Our ref: XA/2025/100270/04-L01

Date: 7 October 2025

ISSUE SPECIFIC HEARING 2 (ISH2) INTO ENVIRONMENTAL MATTERS

BOTLEY WEST SOLAR FARM, OXFORDSHIRE

Title: Illustrative Masterplan
Figure 5.5
 Cable Corridor Plan Overview –
 Land between the Central and Southern Sites east
 and south of Eynsham around the Swinford Bridge

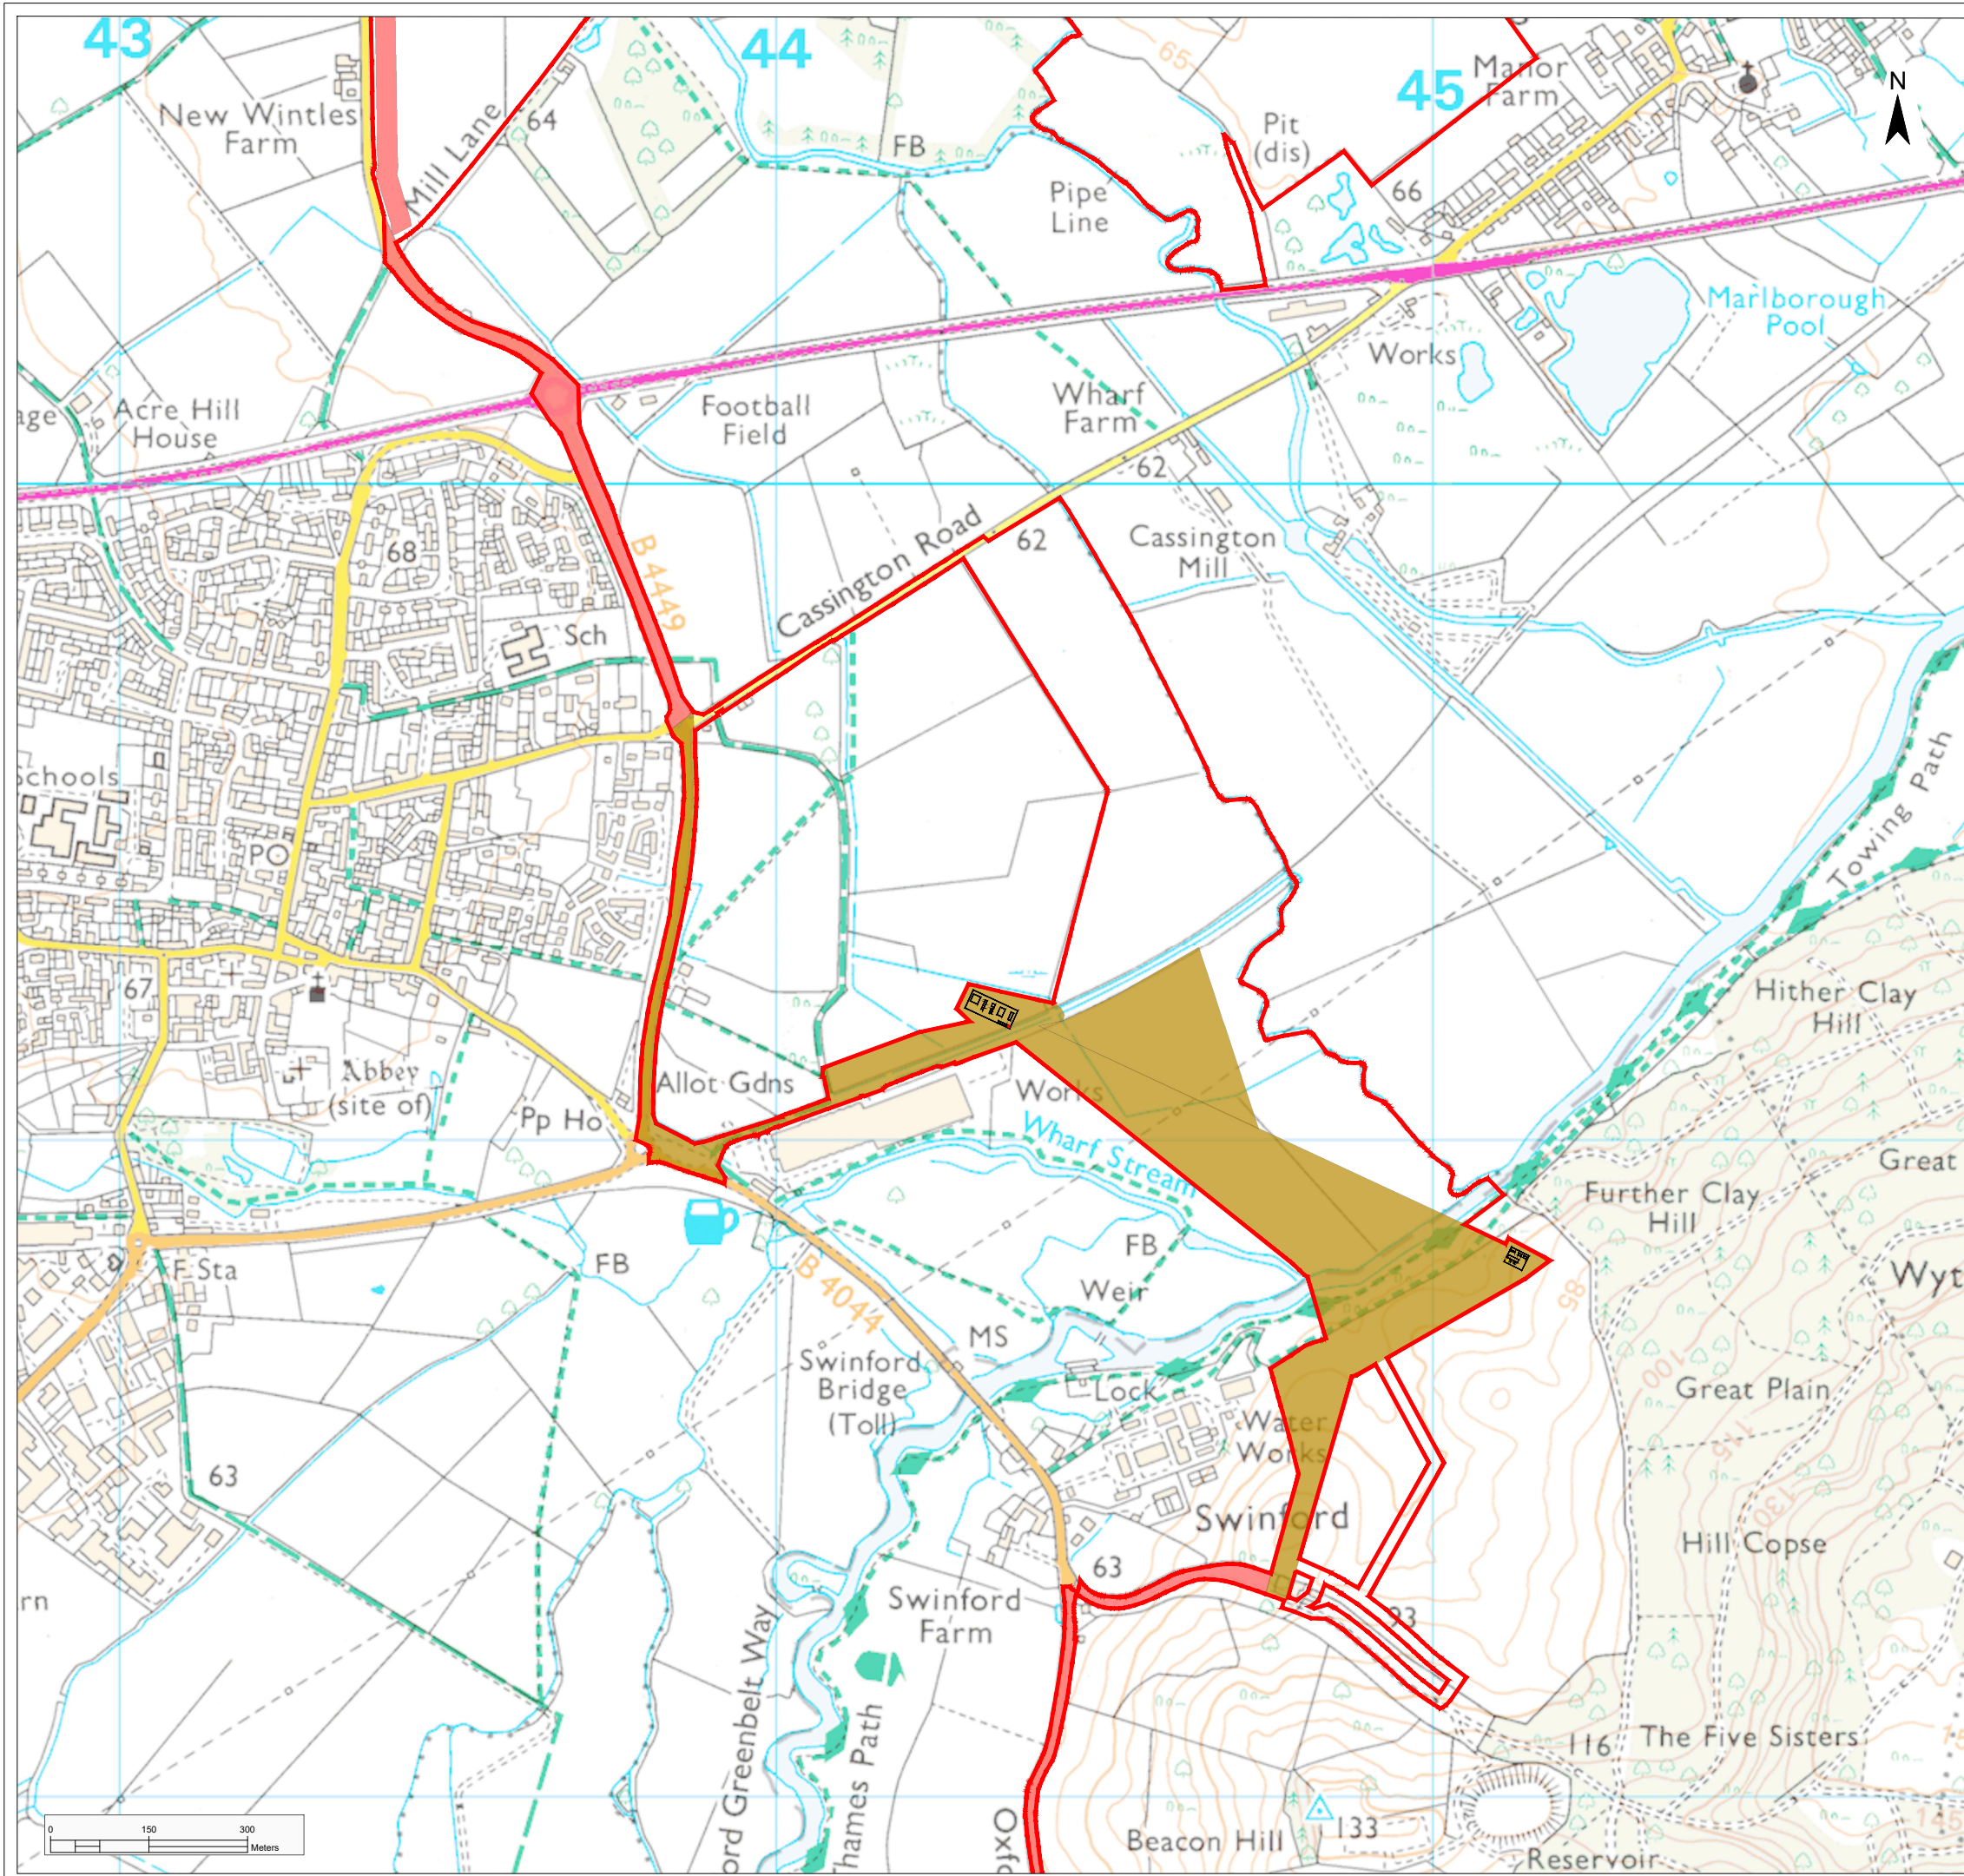
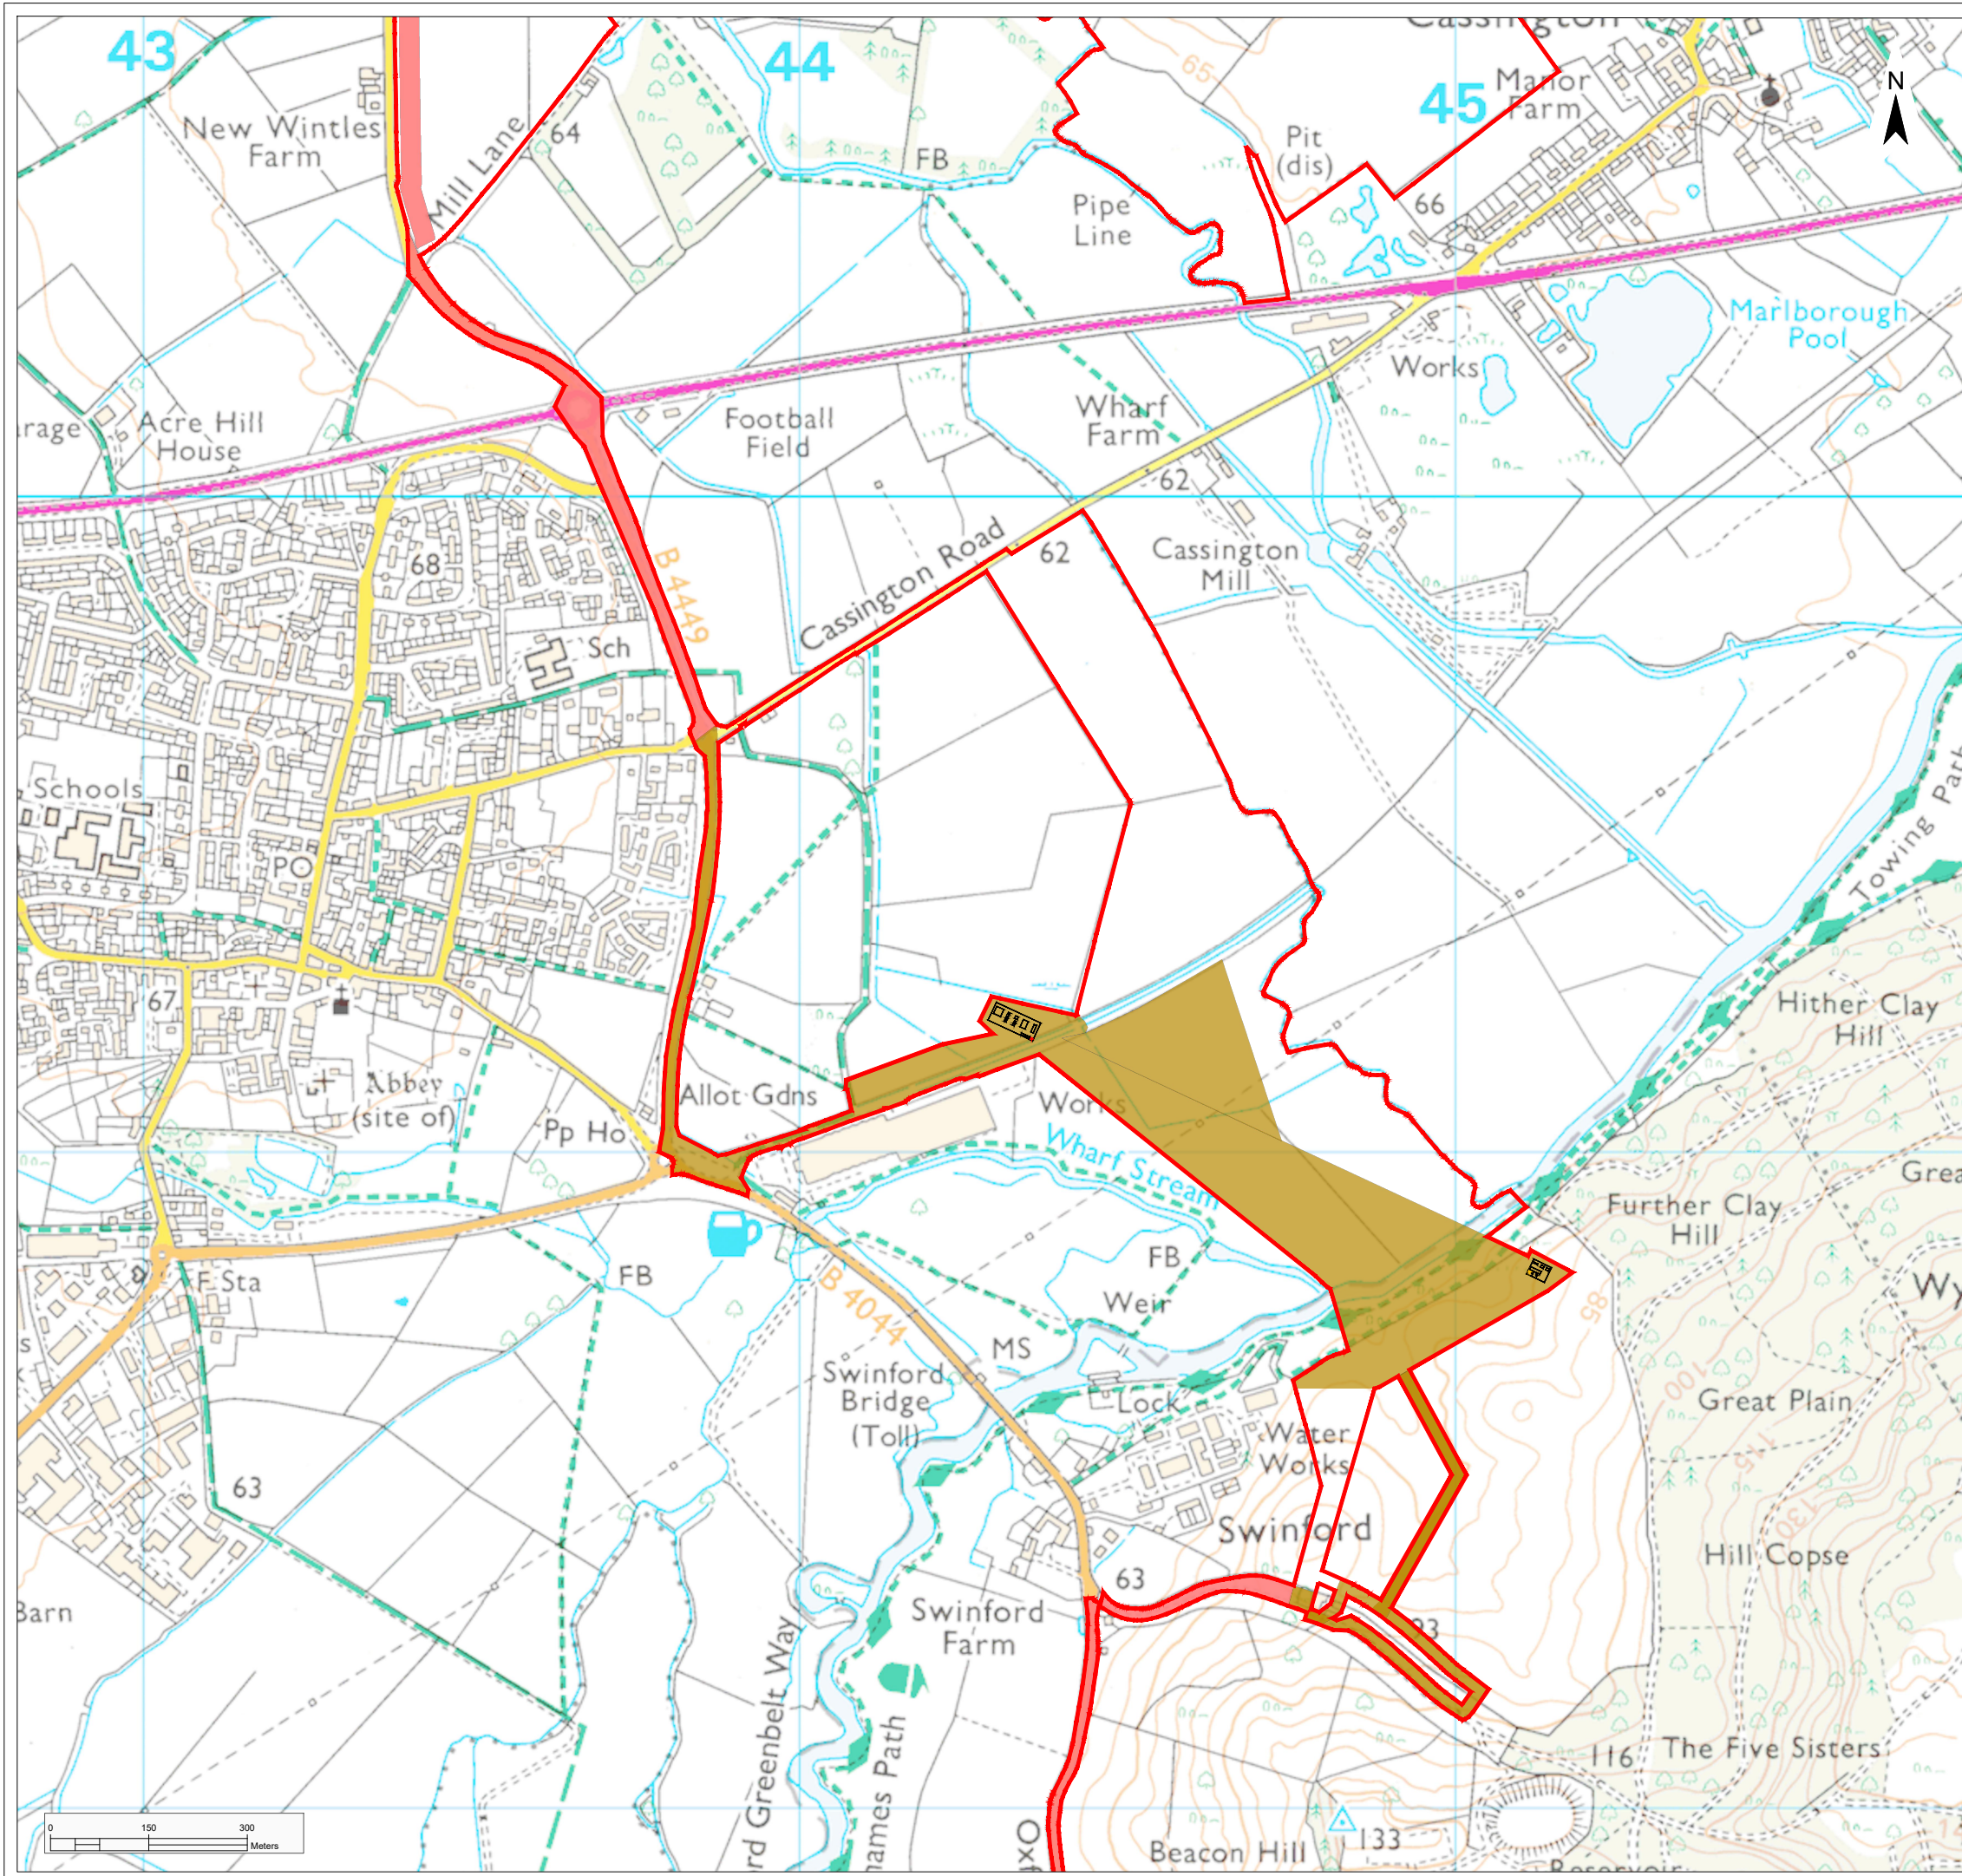
Flood Zones 3a and 3b / ES, FRA	EAFR-009 – Provide mapping that shows Flood Zones 3a and 3b with proposed components and the cable corridor route. Minimise interaction with Flood Zone 3b.					<p>The Swinford HDD entrance pits are shown to be within the extent of Flood Zone 3b within the West Oxfordshire Strategic Flood Risk Assessment. The latest Risk of Flood from Rivers and Sea (RoFRS) dataset shows the chance of flooding from rivers and the sea considering the presence and condition of flood defences. The Swinford HDD entrance pits are at a high-risk classification based on this dataset. A high-risk classification has a greater than or equal to 1 in 30 (3.3%) chance of flooding in any year. I would suggest using the Risk of Flooding from Rivers and Sea dataset for informing the risk to the entrance pits rather than solely the outlines from the River Thames as the RoFRS dataset will incorporate the risk from other watercourses as well such as the lower River Evenlode. In addition to the modelled outlines, the Swinford HDD crossing entrance pits are also shown to be within the Winter 2013/14 recorded flood extent, January 2003 recorded flood extent, and the Winter 2000 recorded flood extent. Given the location of the entrance pits within a high-risk flood area, there is also potential for flood flow routes through the HDD tunnel to the opposite bank of the Thames. The applicant should assess this risk and clearly outline the mitigation measures.</p> <p>The applicant will need to review this with respect to the Swinford HDD entrance pit and provide written justification as to why the entrance pit cannot be moved outside of functional floodplain. In such cases,</p>

<p>appropriate mitigation measures must be presented to manage and reduce flood risk. It is important to note that mitigation measures may remain relevant even if the HDD entrance and exit pits are located within Flood Zone 3a, as this is still an area at risk of flooding.</p>
--	--	--	--	--	--	--	--	---
